**From:** planning  
**Subject:** FW: app3/2016/0177 Higher Boyce Farm

**From:** Bloomer, David [<mailto:David.Bloomer@lancashire.gov.uk>]  
**Sent:** 08 March 2016 09:41  
**To:** Stephen Kilmartin  
**Cc:** LHS Customer Service; planning  
**Subject:** app3/2016/0177 Higher Boyce Farm

### **Highway comments on application 3/2015/0961**

**Location Plan**  
Scale 1:1250

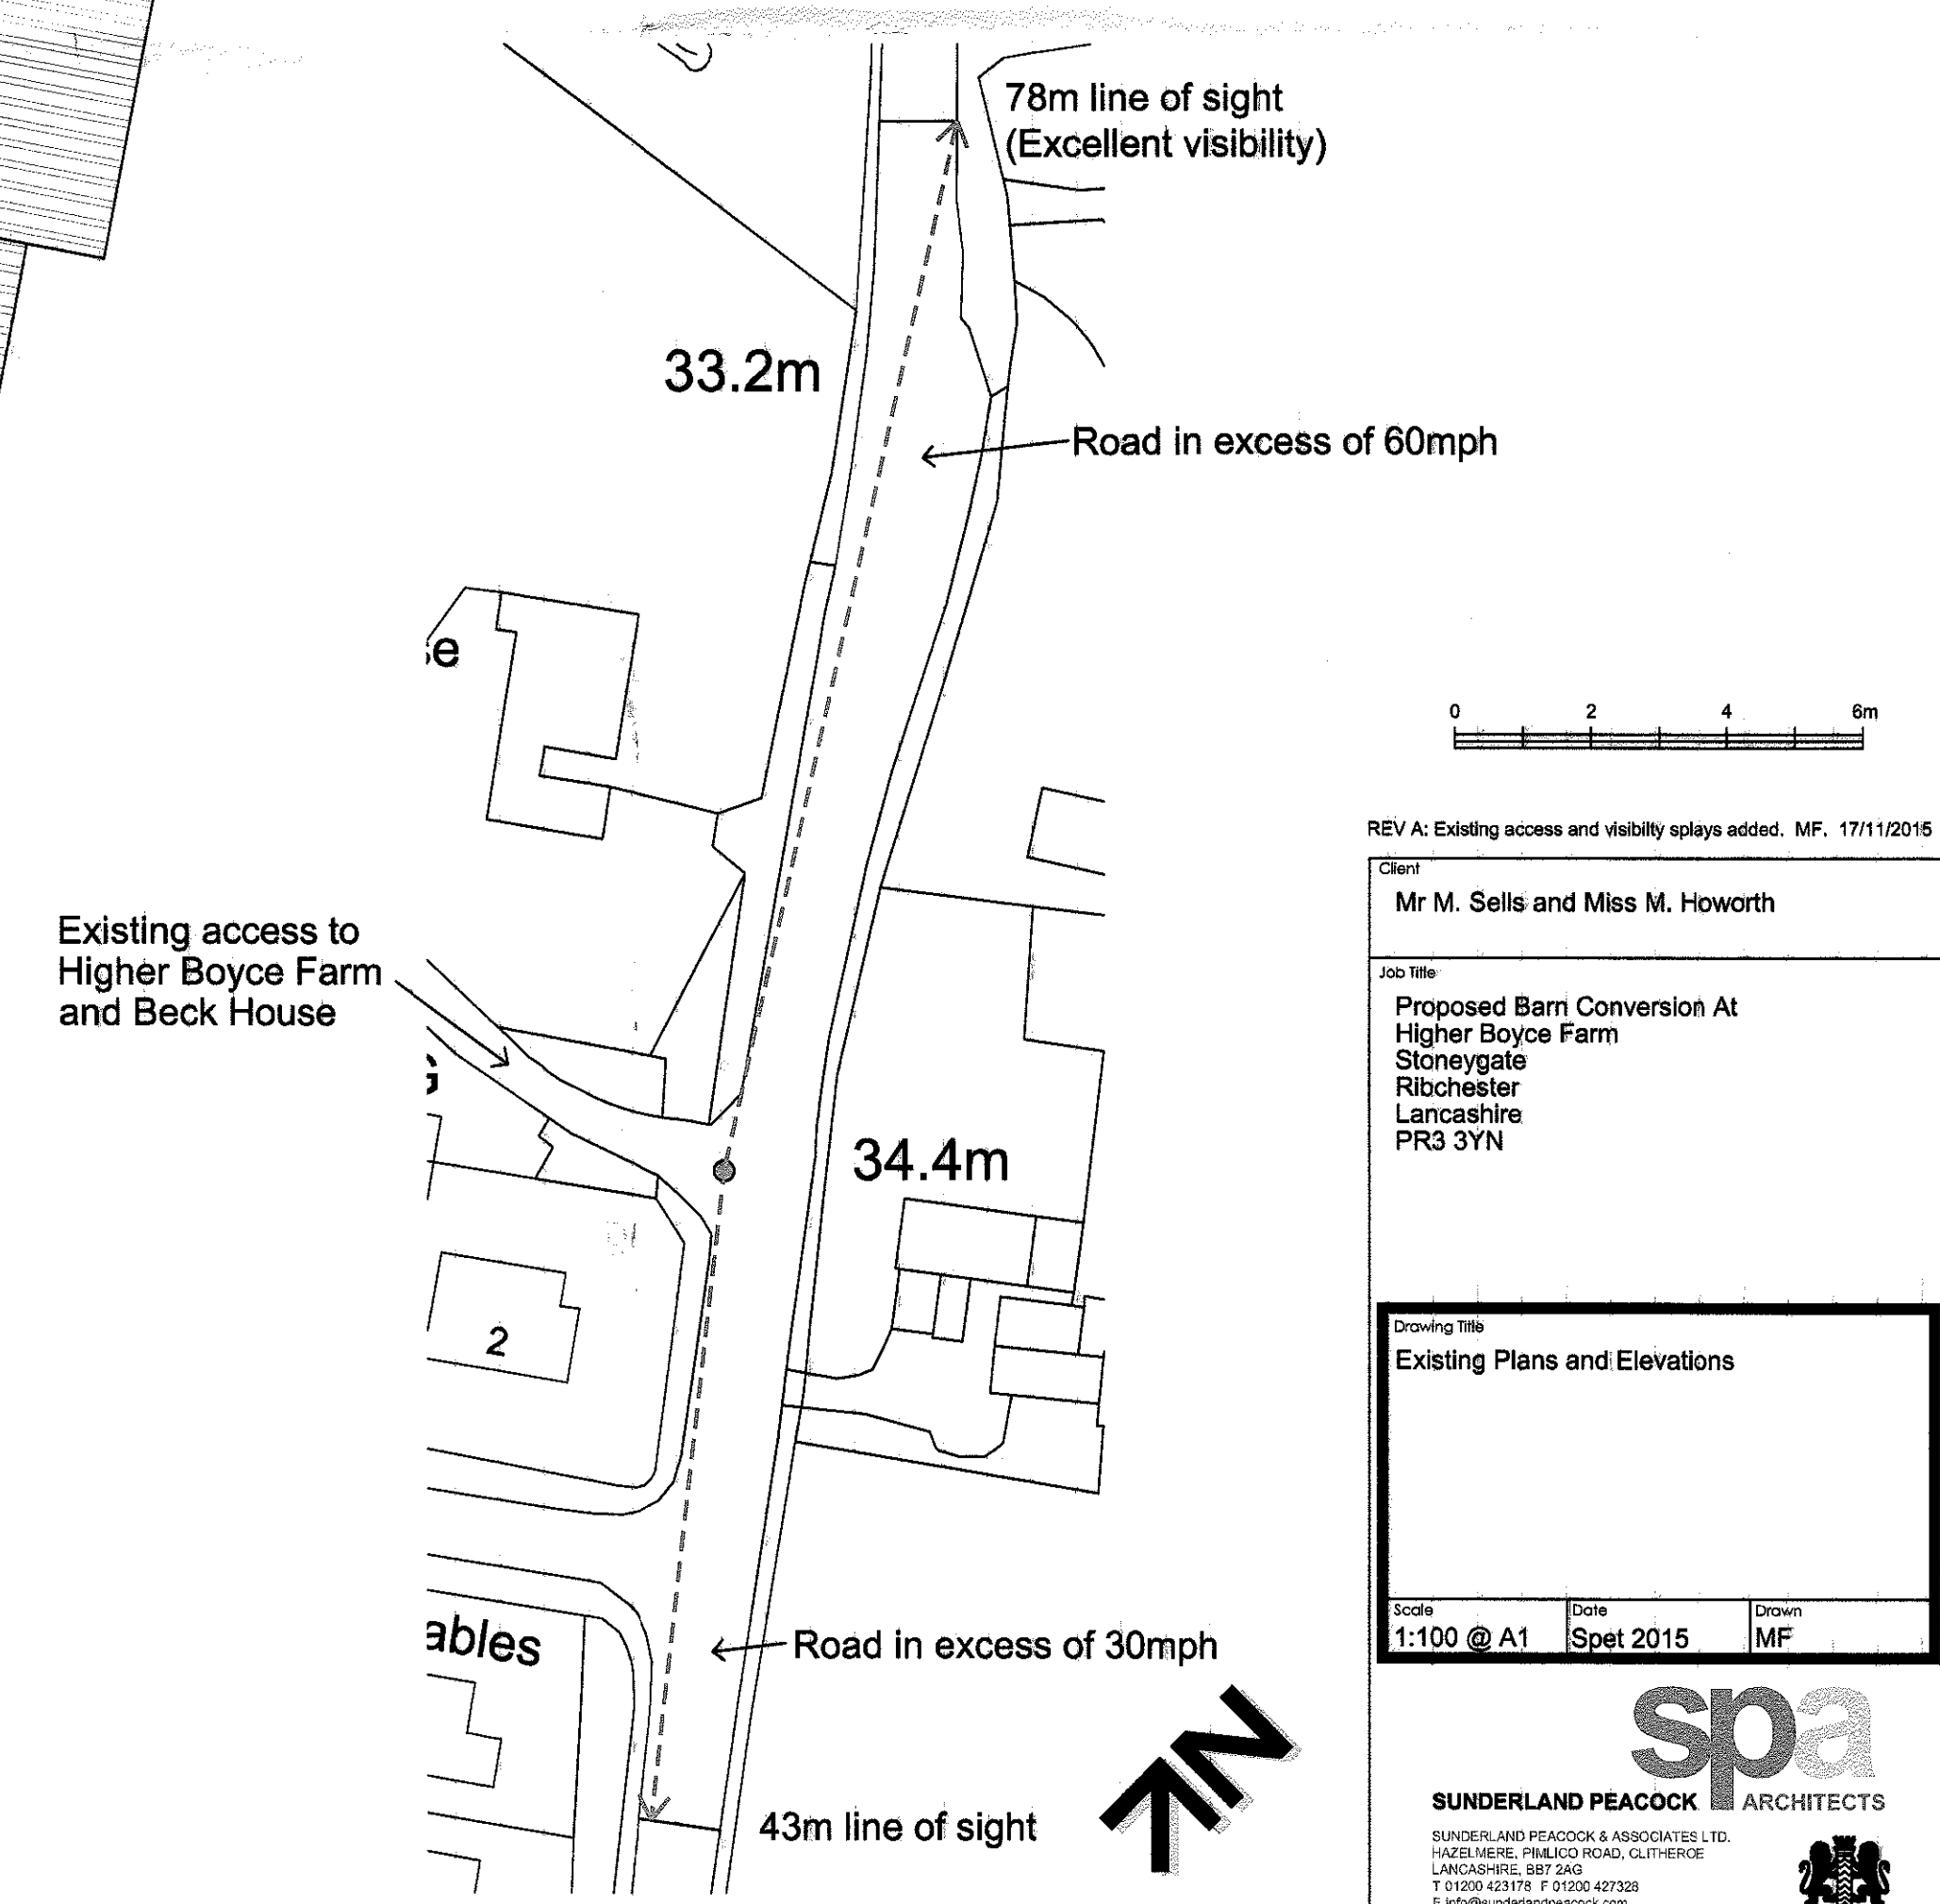
the proposal will increase the number of trips to and from the site,. Currently there is a single track lane extending from Stoney Gate Lane to the site which also serves as a public right of way. Due to the anticipated increase in vehicle movements I would want to see the access between Stoney Gate lane between the access and The cattle grid widened to 6.0m to allow opposing vehicles to pass and the creation of a passing place suitable to accommodate a tractor and trailer on the south westerly side of the track in the vicinity of the "summerhouse" in the garden of Catherine House.

- a) The parking for unit 1 is unlikely to prove attractive to the residents due to distance from the dwelling with the likelihood of parking occurring in the access with vehicles reversing out onto the public footpath. A more suitable option would be to bring the parking provision closer to the dwelling and use proposed access as a turning head.
- b) The 2 parking for unit 2 projects into the access to the existing farmhouse access road and partially obstructs the public footpath. In addition the reversing area would appear to be outside the control of the residents and may on occasion be obstructed. The single space does not have any identified area for the vehicle to turn around which would result in vehicles reversing along the public footpath.
